Addendum 01

Date: November 12, 2010

To: Wright Ryan Construction (Construction Manager)
From: Ben Walter, CWS Architects
Regarding: **Oak Street Apartments** – Portland, Maine
Subject: **Addendum 01**

SKM-1

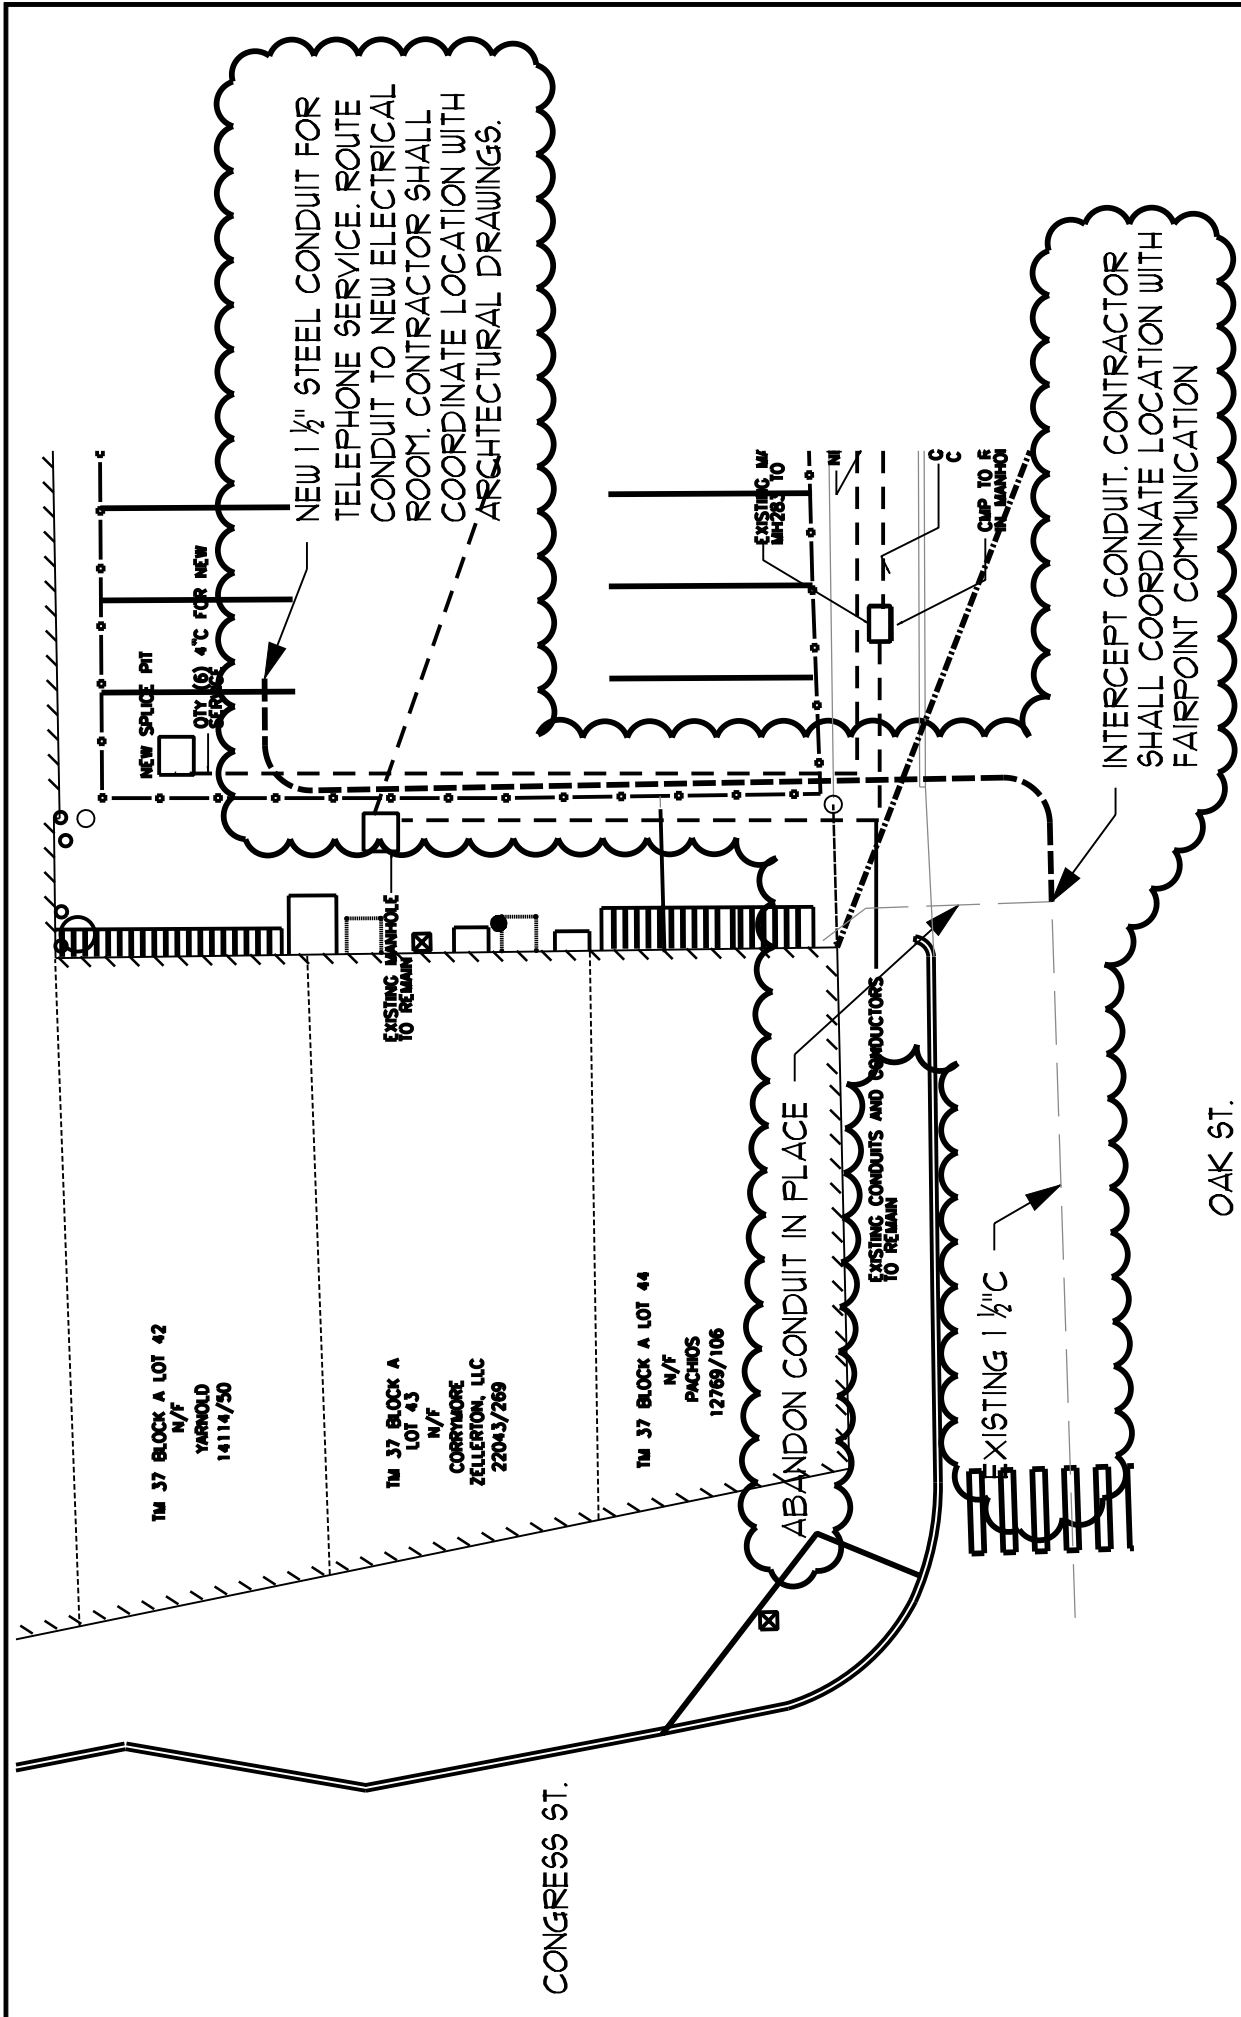
21. Drawing M1.4 - Add solar collector piping from 4th floor ceiling cavity up to collectors on roof as shown on SKM-1.
